From:
Sent: 04 January 2024 17:51
To: DCAdmin
Subject: Application for planning comments

I am writing to object the planning notice of 2023/93556. The property is near our property of 133 Upper Batley lane.

I await your response on this matter of 216 Woodlands Road WF170QS.
Number 2023/93556.

Rev - : DD-MM-YYYY : Initial : Issue.
Drawing Number 23-110 - P - 03

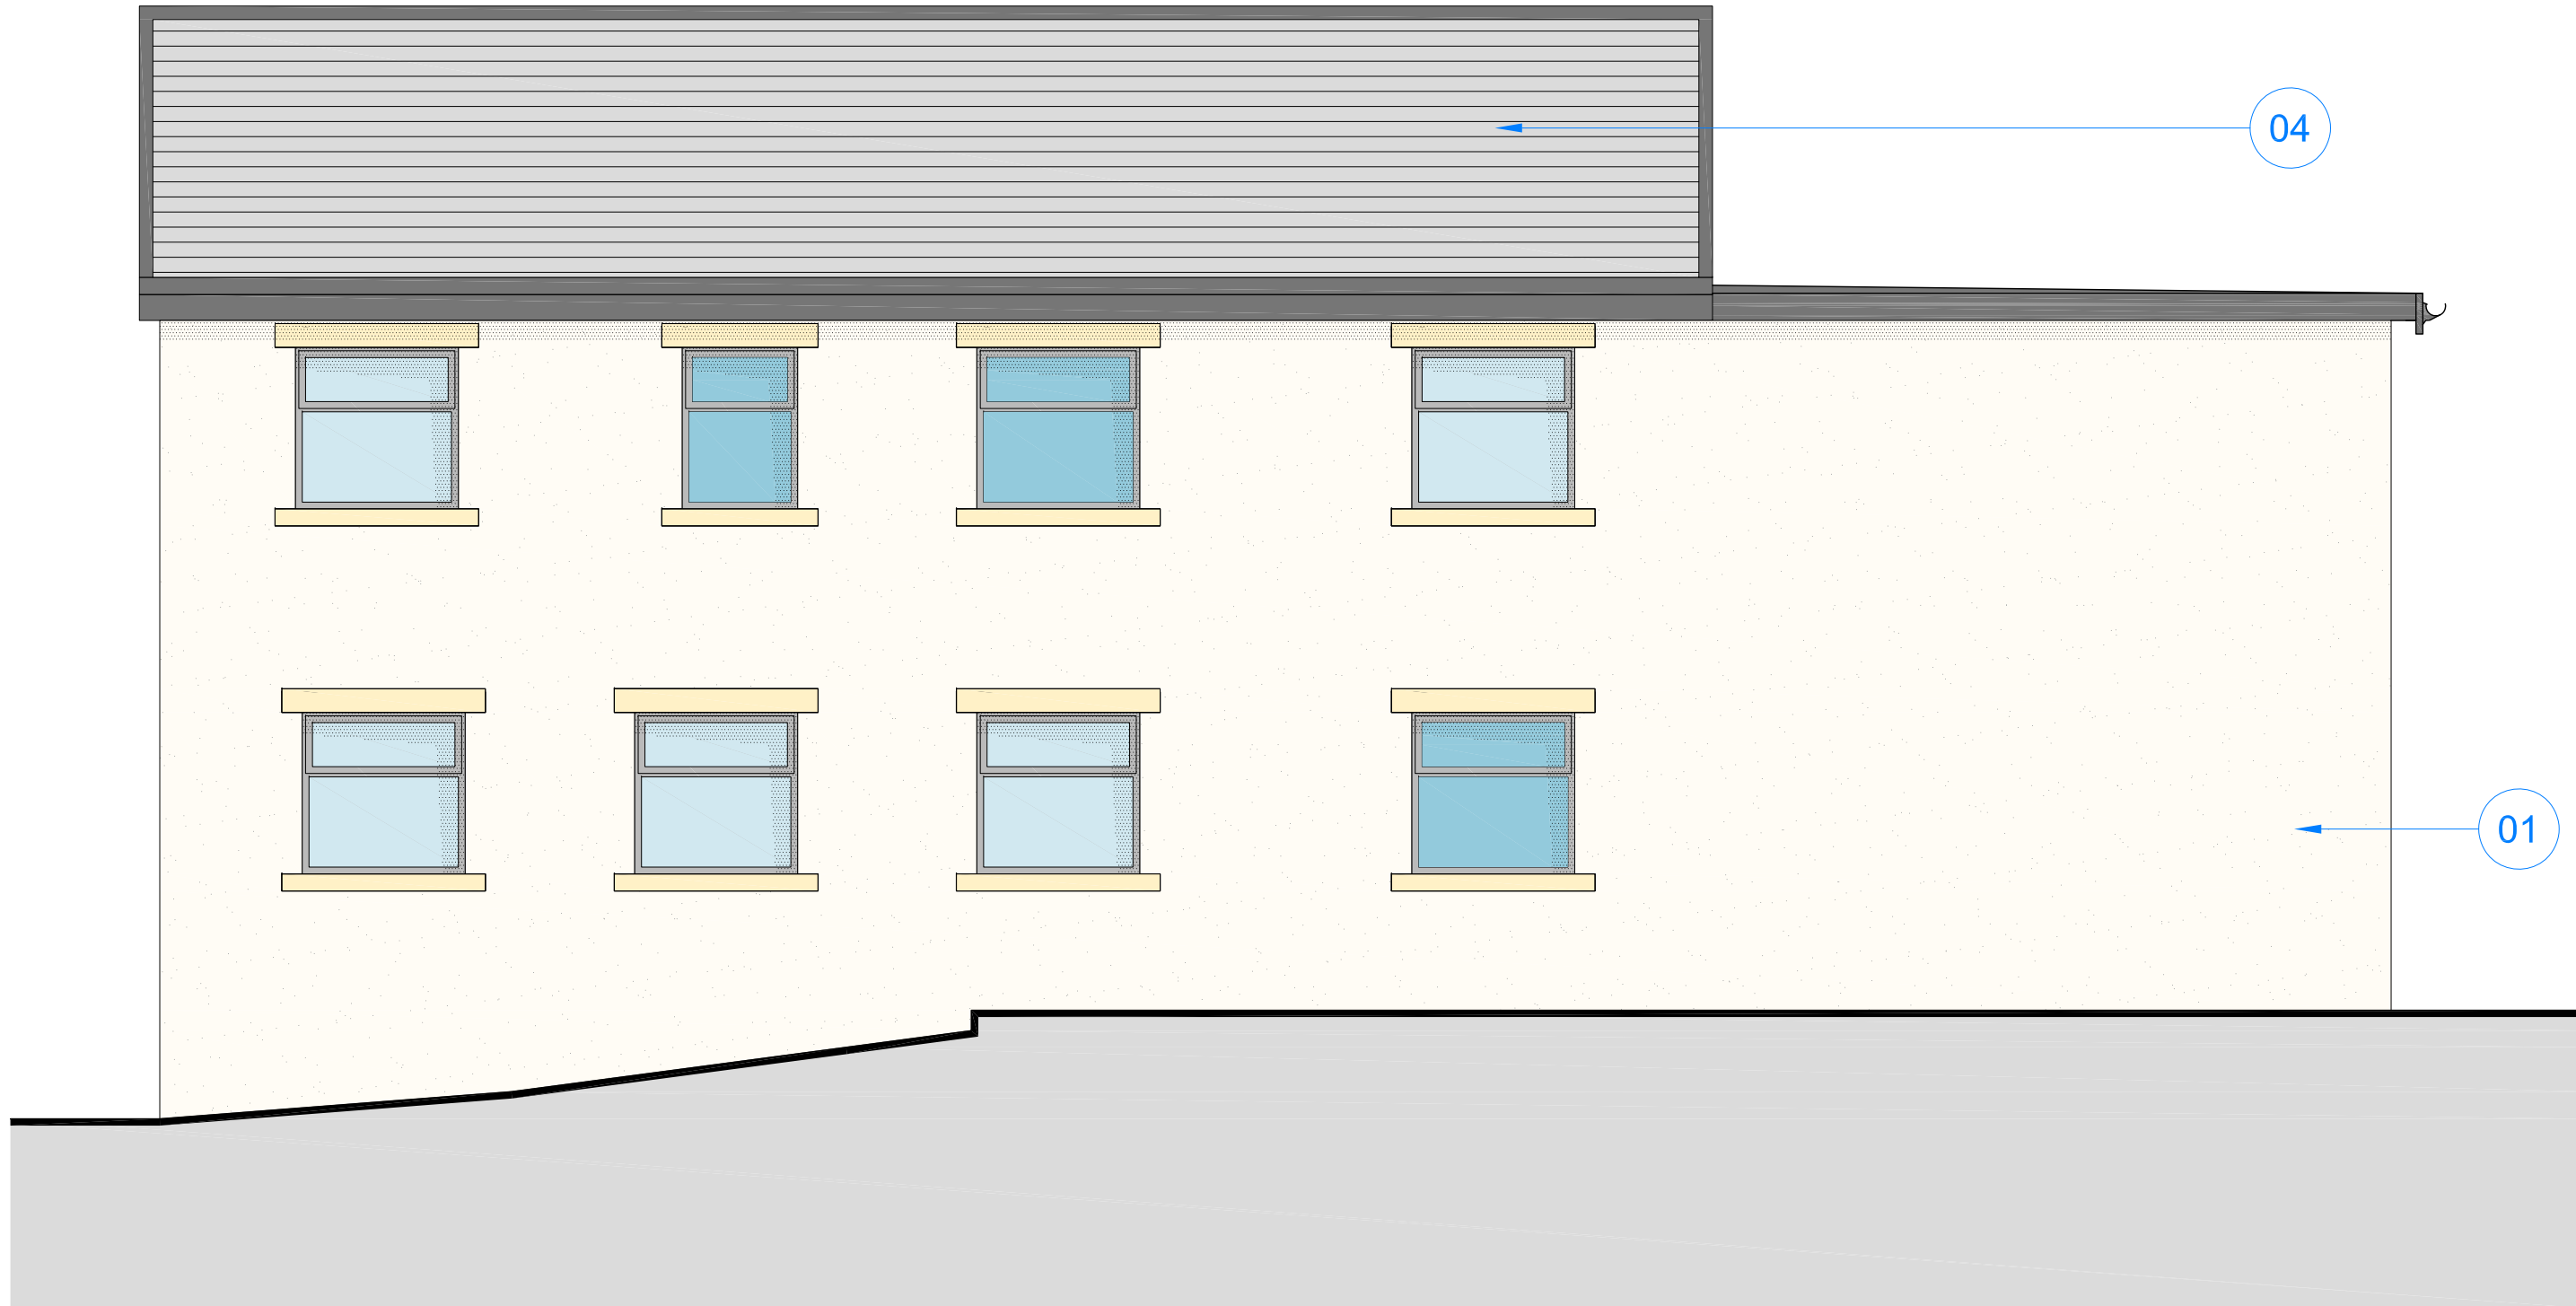
This is a well sought after area and we invested in a long term private residential house. However this 6 bedroom extension with balcony and roof based heaters have a major impact on how we will live our daily lives.

I completely reject the plans based on many factors mentioned but also raise concerns of the slope of our gardens and how they plan to build into this which could affect our property foundations. We have taken advice from builders on this matter.

PROPOSED REAR ELEVATION
Scale 1:50@A1

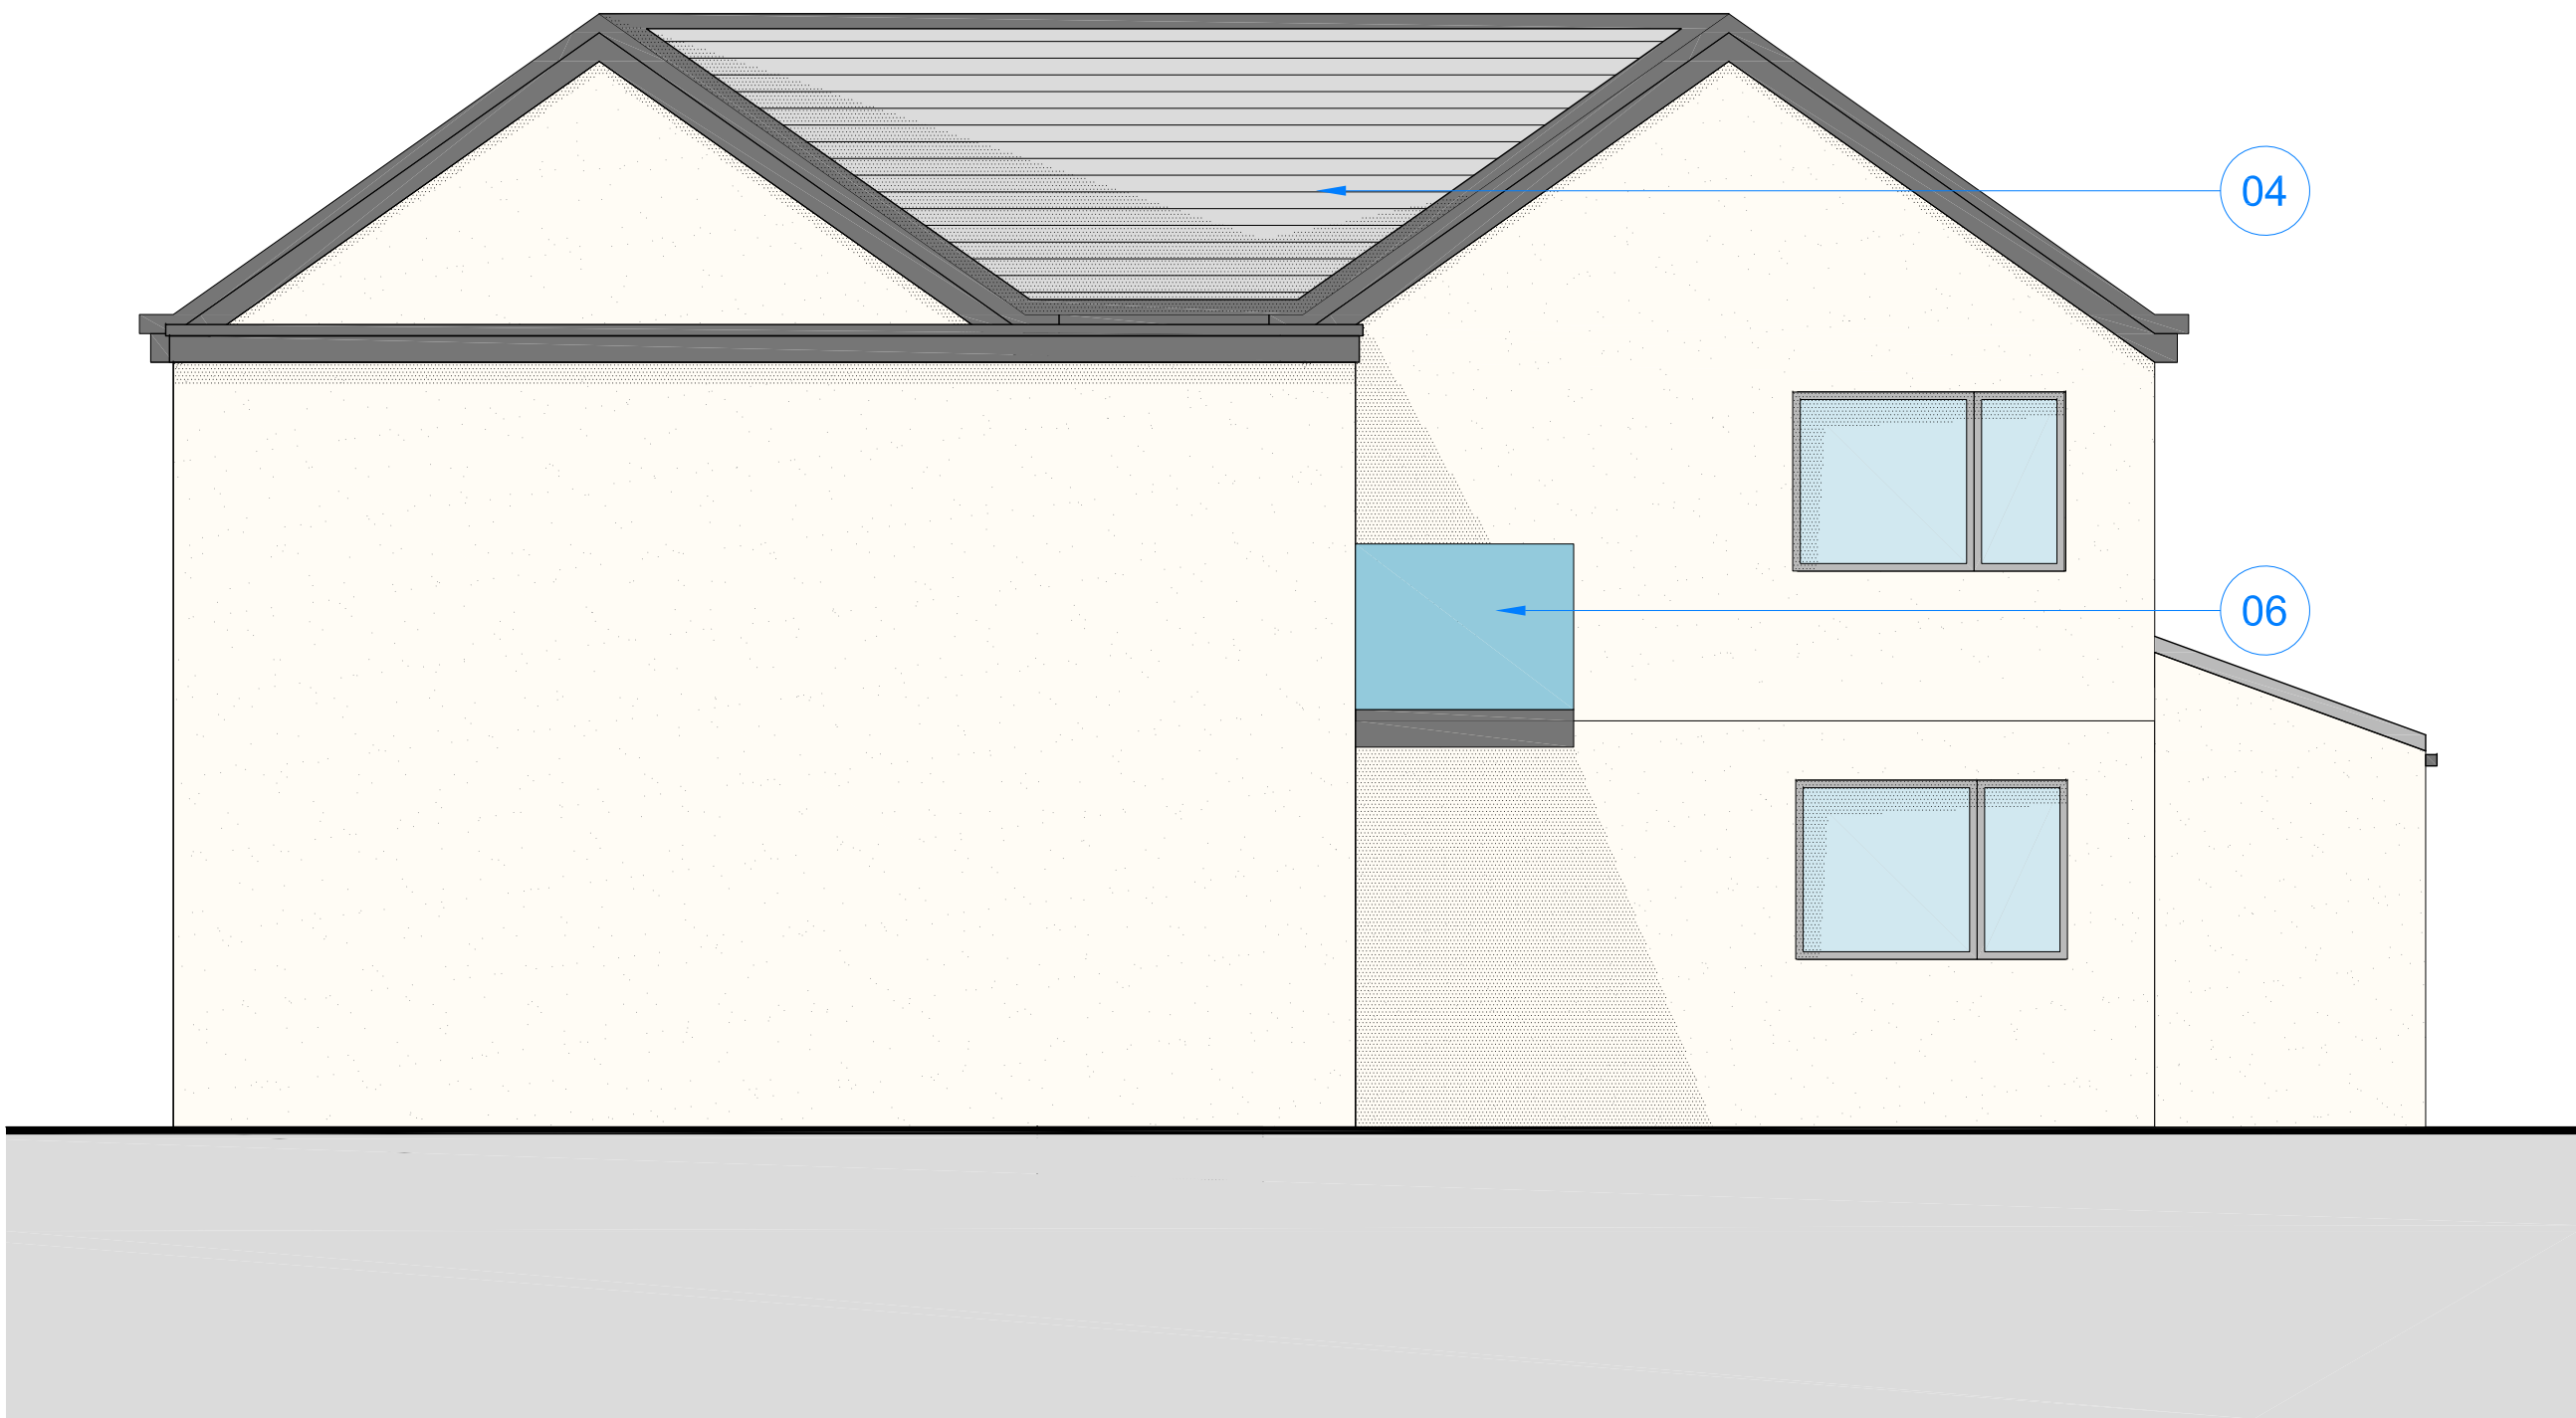
When looking at the plans there are many concerns which cause an invasion of our privacy of our own property. There are plans for a balcony which will overlook our property and will invade privacy and our quality of life sitting in our back garden will be massively affected by being overlooked.

The balcony will be made of glass and will intrude our space and this will be at a very high level.

Windows will be visible from the height and this will intrude both myself and my neighbours house.

I also have concerns about how this would affect our property financially due to the overlooked elements of the glass and windows with veranda this could impose noise factors when the balcony is used again having an impact on daily life.
